KITITAS COUNTY

DEPARTMENT OF PUBLIC WORKS

TO: All Staff
FROM: Public Works Plan Review Team
DATE: October 6, 2025 Survey Updated 11/4/2025
SUBJECT: BL-25-00014 Voshall

**PART OF THE SECTIONS 22 & 23,  
TOWNSHIP 18 NORTH, RANGE 18 EAST, W.M.**

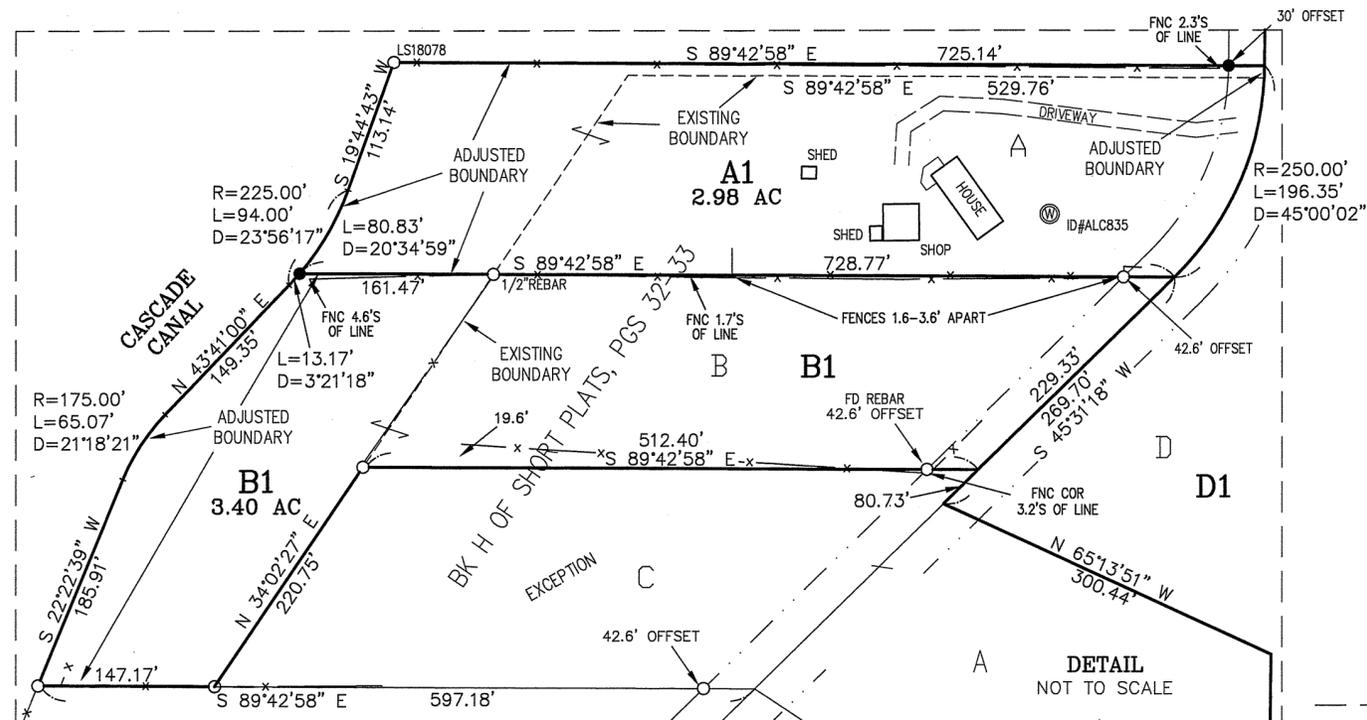
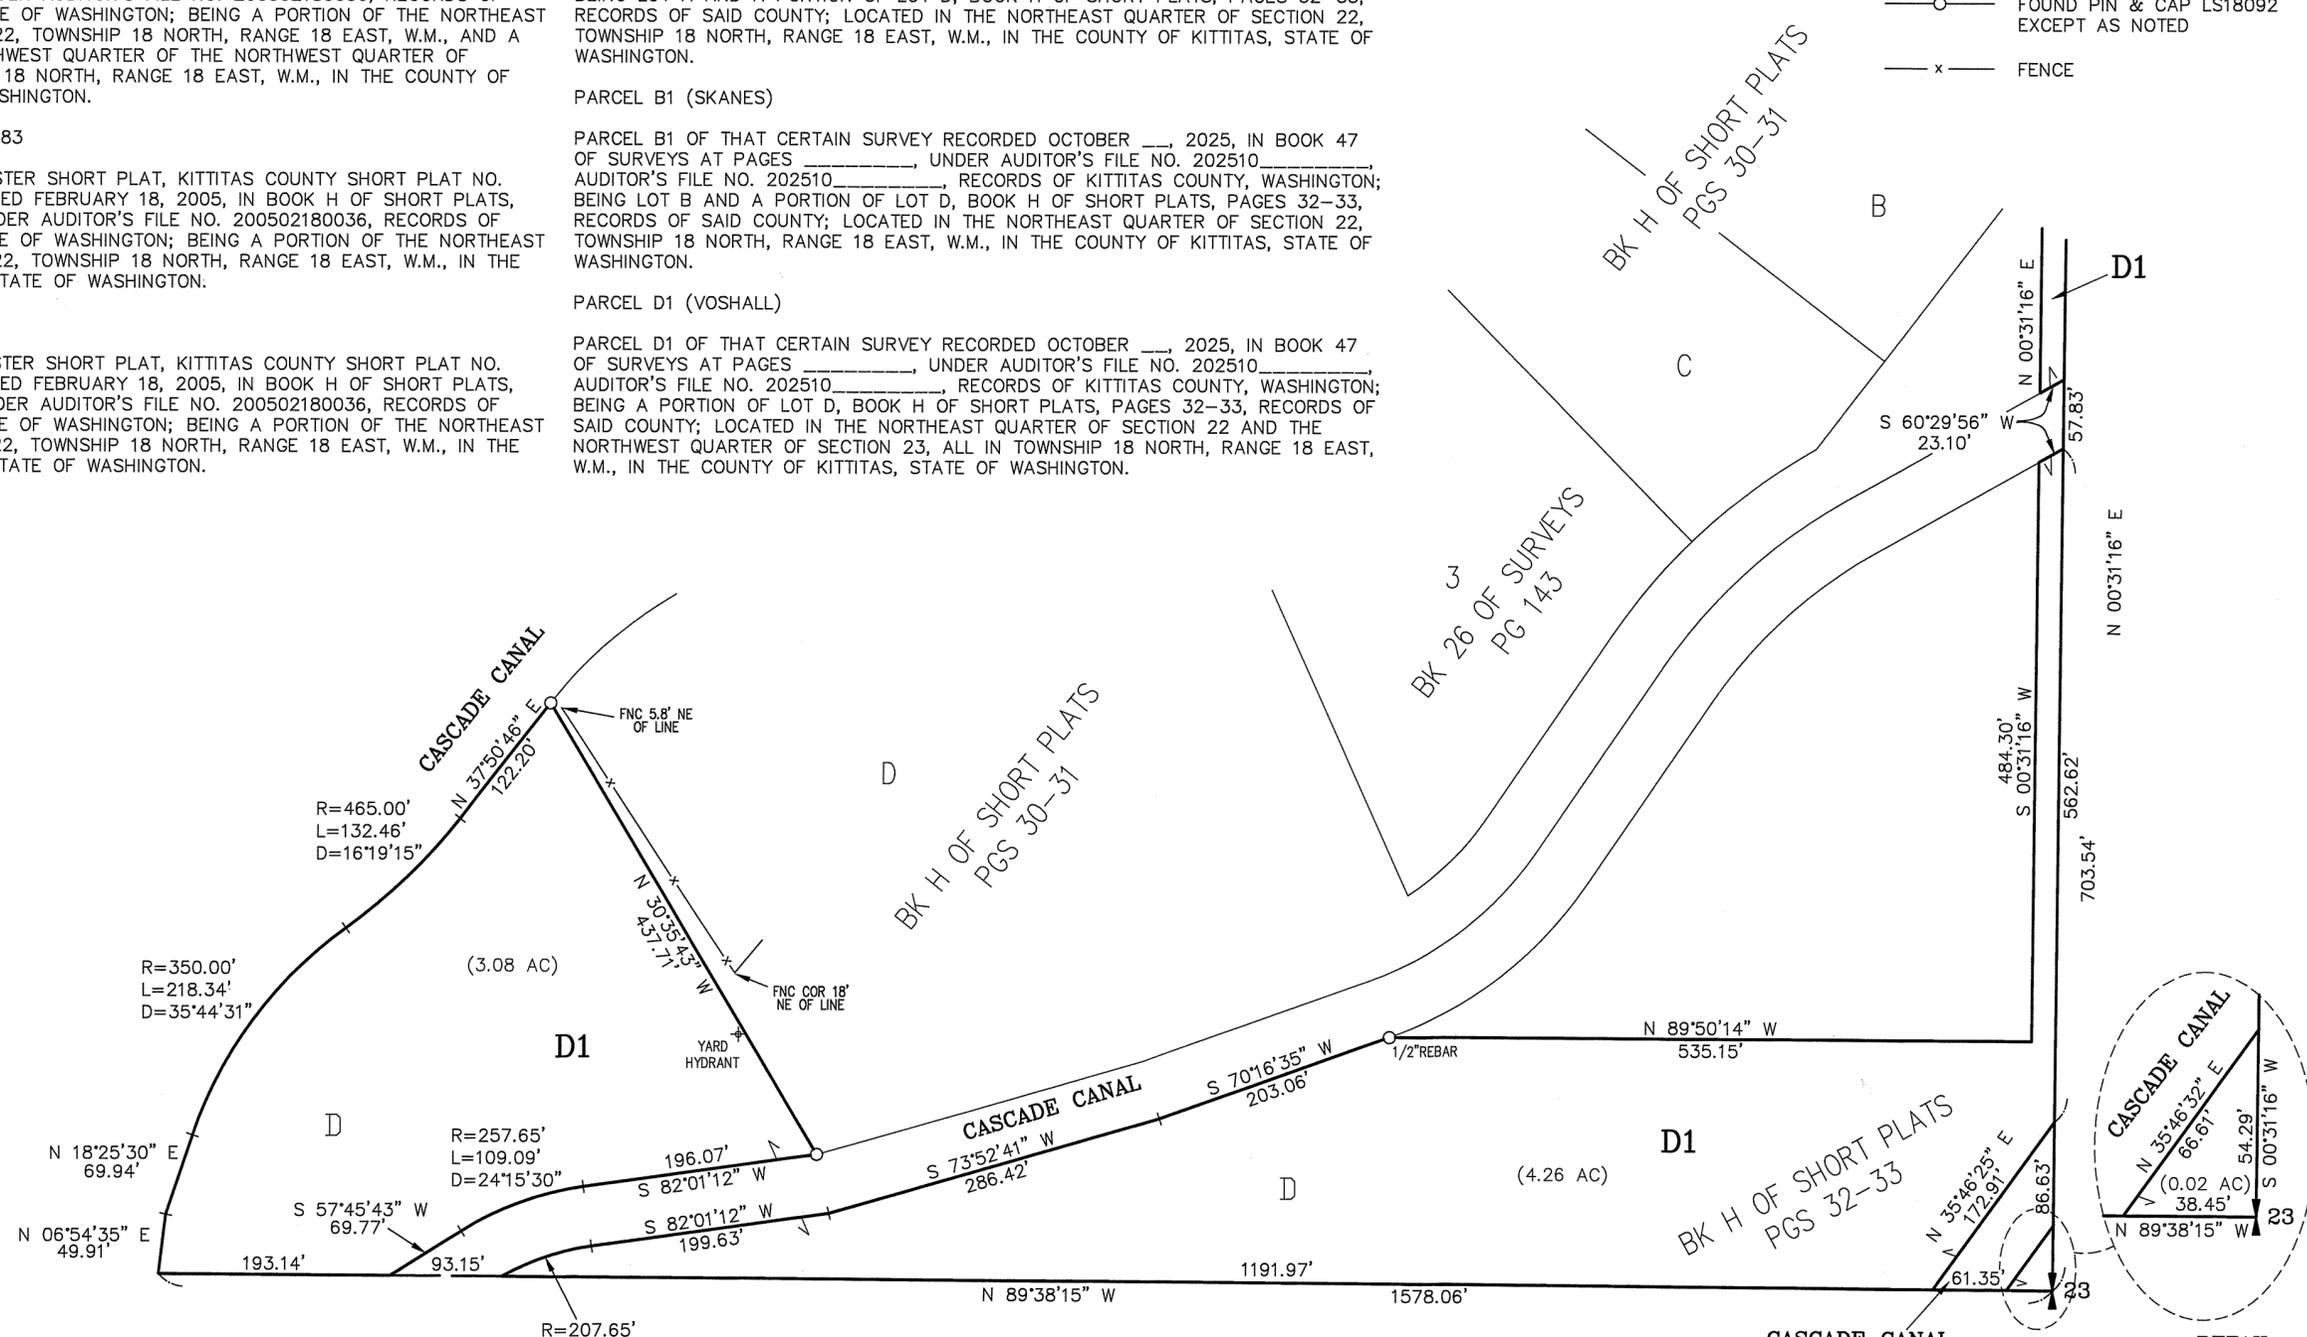
SURVEY	<p>As the application does not contain a survey map, comments are reserved until final submittal. (JT)</p> <p>UPDATE 11/04/2025</p> <ol style="list-style-type: none"> 1. Please include "Record of Survey" at the top of page. 2. Please include section corner descriptions, or note as calc points. <p>OF NOTE</p> <p>Lot Closures were not included in the submittal documents. As this BLA generally follows existing lot lines, boundaries were compared to surveys of record rather than review lot closures. No Lot Closures required.</p>
TRANSPORTATION CONCURRENCY	<p>No transportation concurrency management requirement for this project. (KAH)</p>
FLOOD	<p>The proposed project is not within a FEMA identified special flood hazard area (100-year floodplain). A floodplain development permit is not required. (RC)</p>
